# KITITAS COUNTY

**TO:** All Staff  
**FROM:** Public Works Plan Review Team  
**DATE:** May 28, 2025  
**SUBJECT:** LP-25-00003 Brown Road Estates LLC

**1601 BROWN ROAD PLAT  
PART OF SECTIONS 3 & 4, T. 17 N., R. 18 E., W.M.  
KITITAS COUNTY, WASHINGTON  
- PRELIMINARY PLAT -**

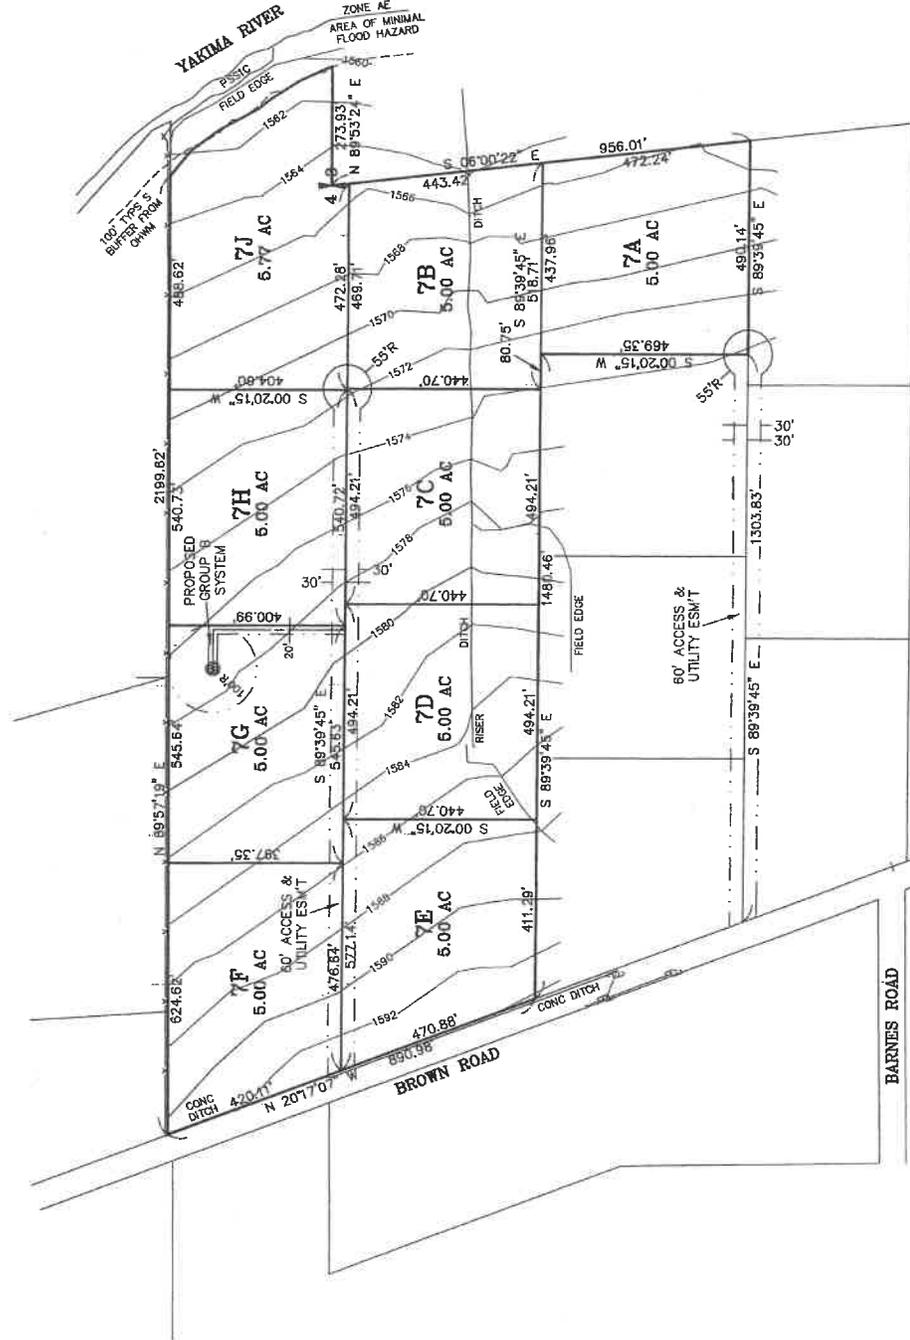
<b>ENGINEERING</b>	<p>There is already an existing grading permit associated with this project (GP-25-00002).</p> <p>Road certification will be required prior to final plat. (CBP)</p>
<b>SURVEY</b>	<p>The following elements will need to be added to meet the requirements of a Preliminary Plat. This does NOT address comments for Final.</p> <ol style="list-style-type: none"> <li>1. Survey legend needs to be shown.</li> <li>2. Record Land descriptions need to be shown, matching subdivision guarantee of record.</li> <li>3. Basis of bearing needs to be addressed.</li> <li>4. Engineer of Record needs to be shown</li> <li>5. Adjacent subdivisions need to be labeled.</li> <li>6. Easements shown shall include notation if they are existing or proposed.</li> <li>7. Brown Road needs to include width, ownership and surfacing.</li> </ol> <p>OF NOTE</p>
